CITY OF ALBUQUERQUE

**RE: Coors Pavilion Subdivision Lots 2 & 3
9154 Coors Blvd
Grading Plan
Engineer's Stamp Date: 3/1/2017
Hydrology File: G11D069A**

Based upon the information provided in your submittal received 3/24/17, the Grading Plan is approved for Site Development for Building Permit.

C-101

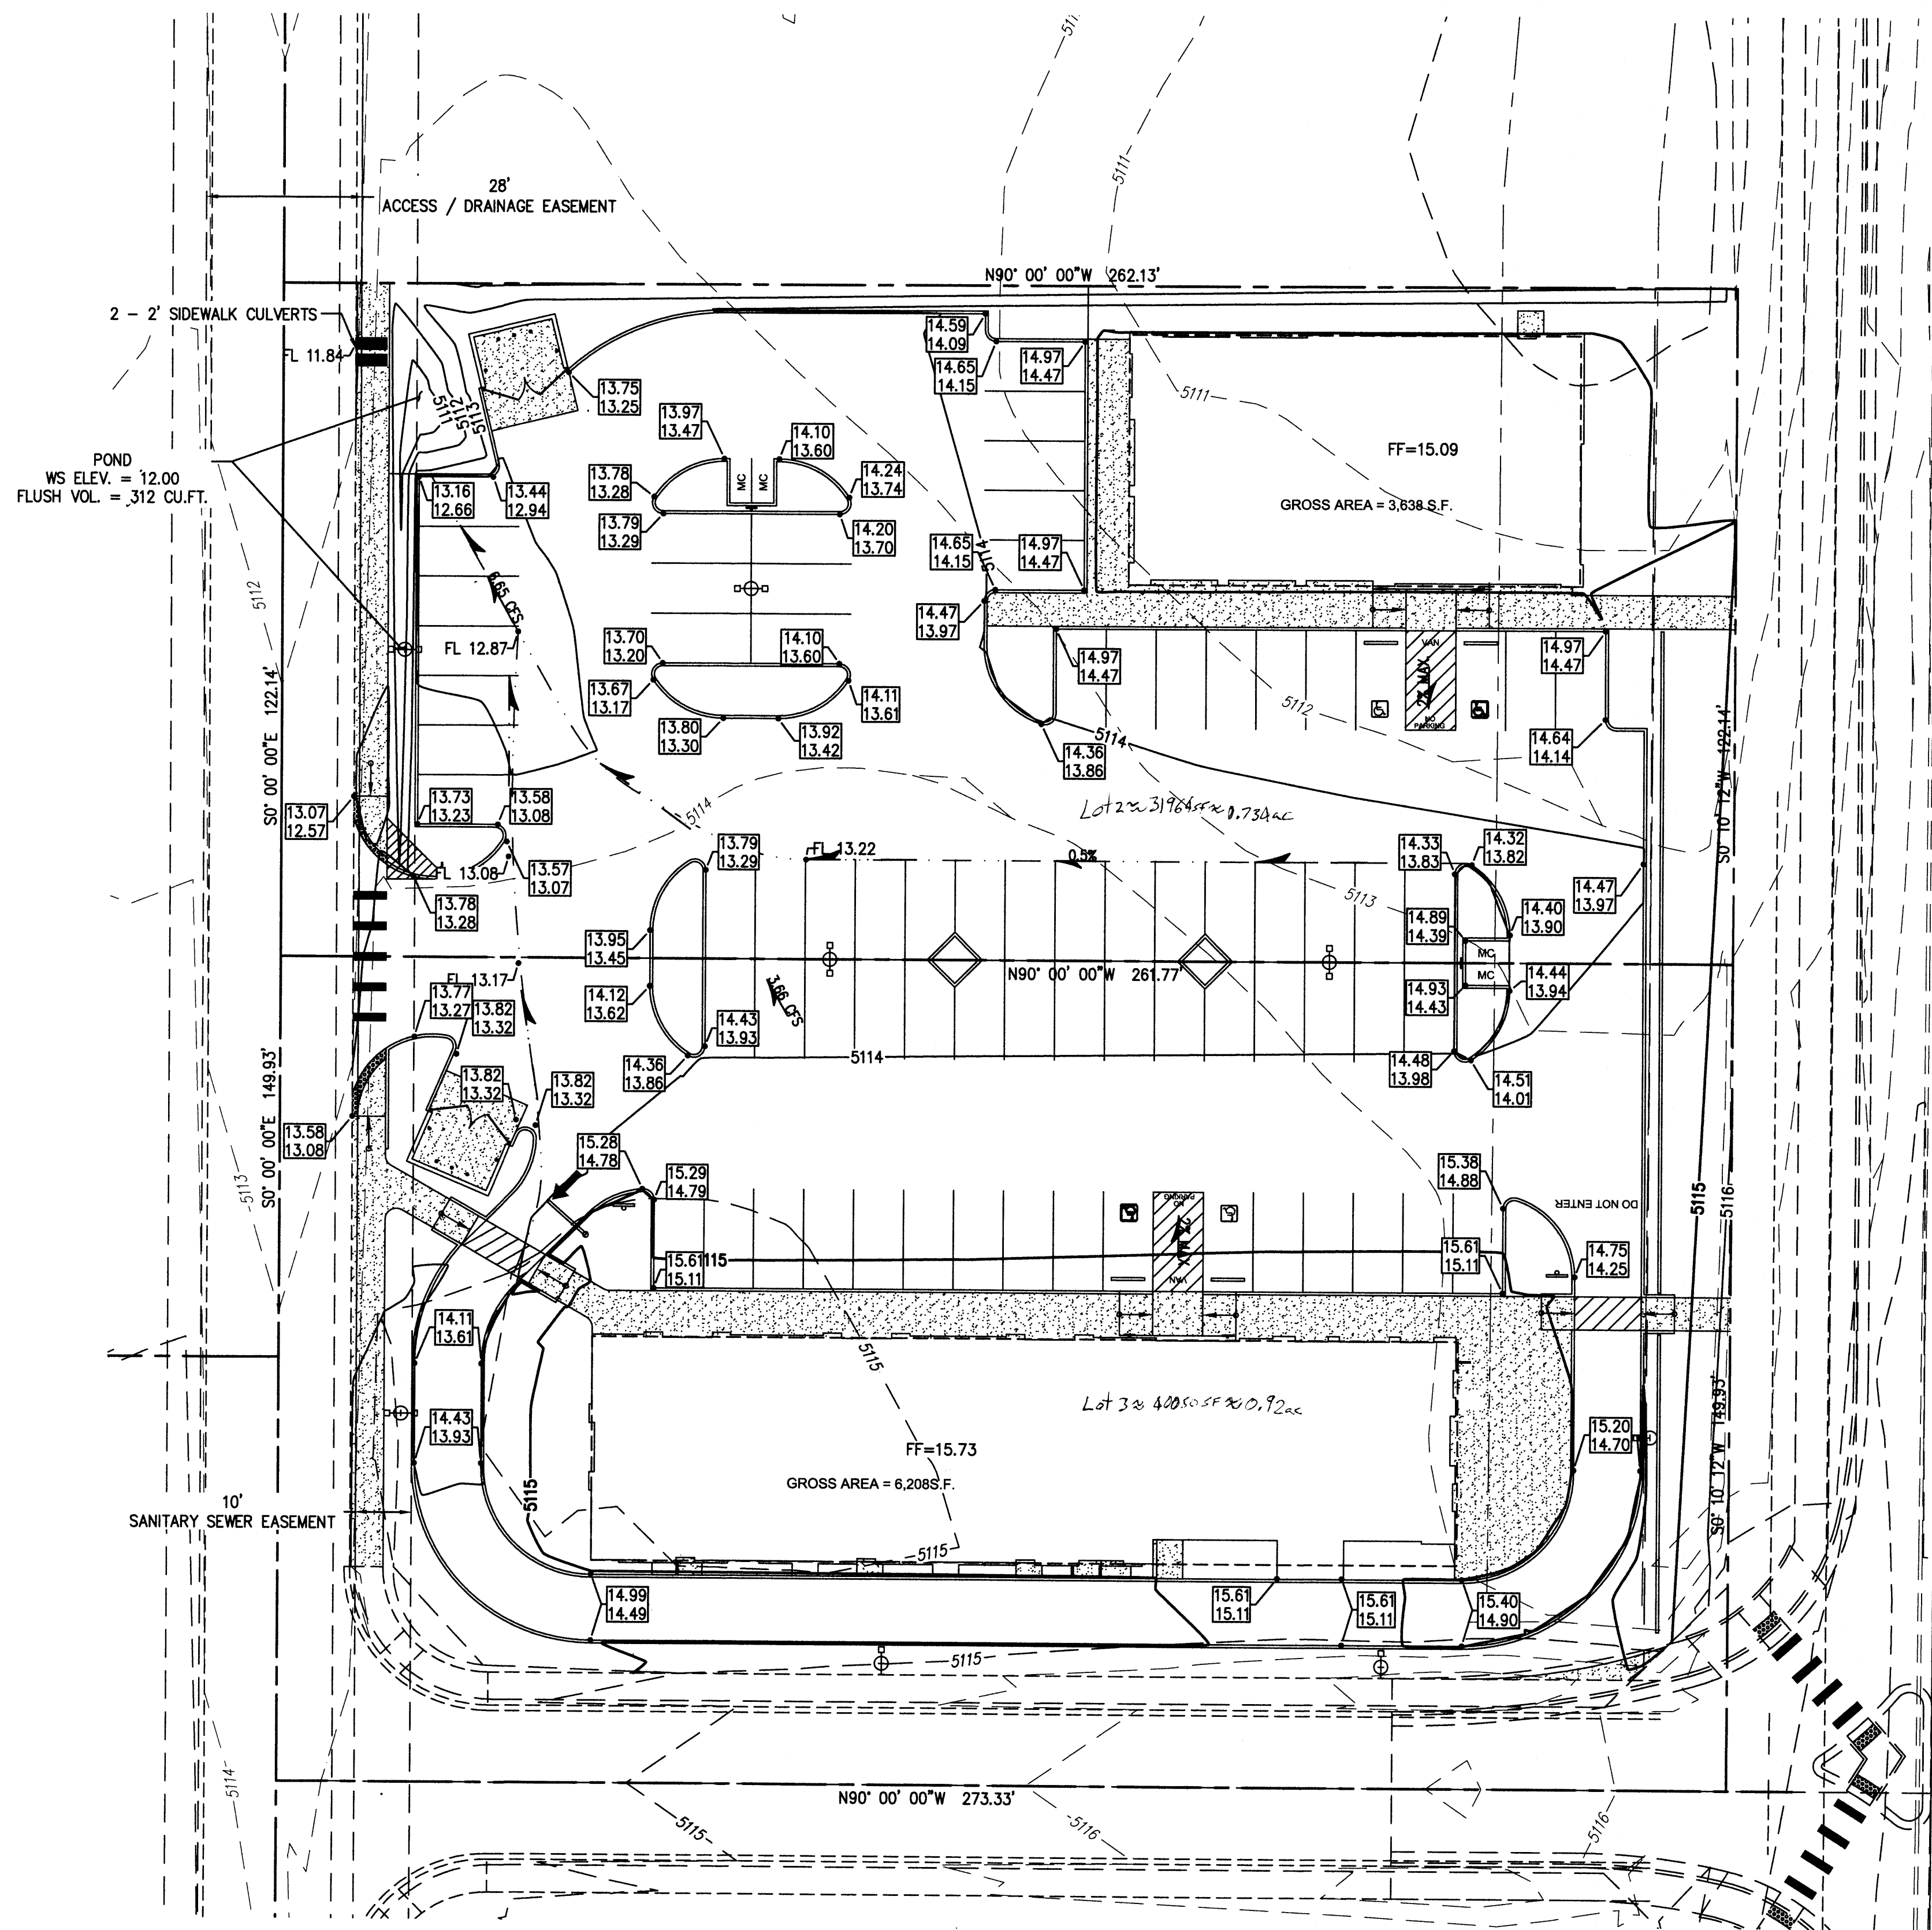
1. Prior to Final Plat, a cross-lot drainage easement will be required for Lot 2 for the benefit of Lot 3.
2. Are either of these buildings restaurants? If so, provide trash enclosure containment and drainage through a grease trap and into the sanitary sewer.
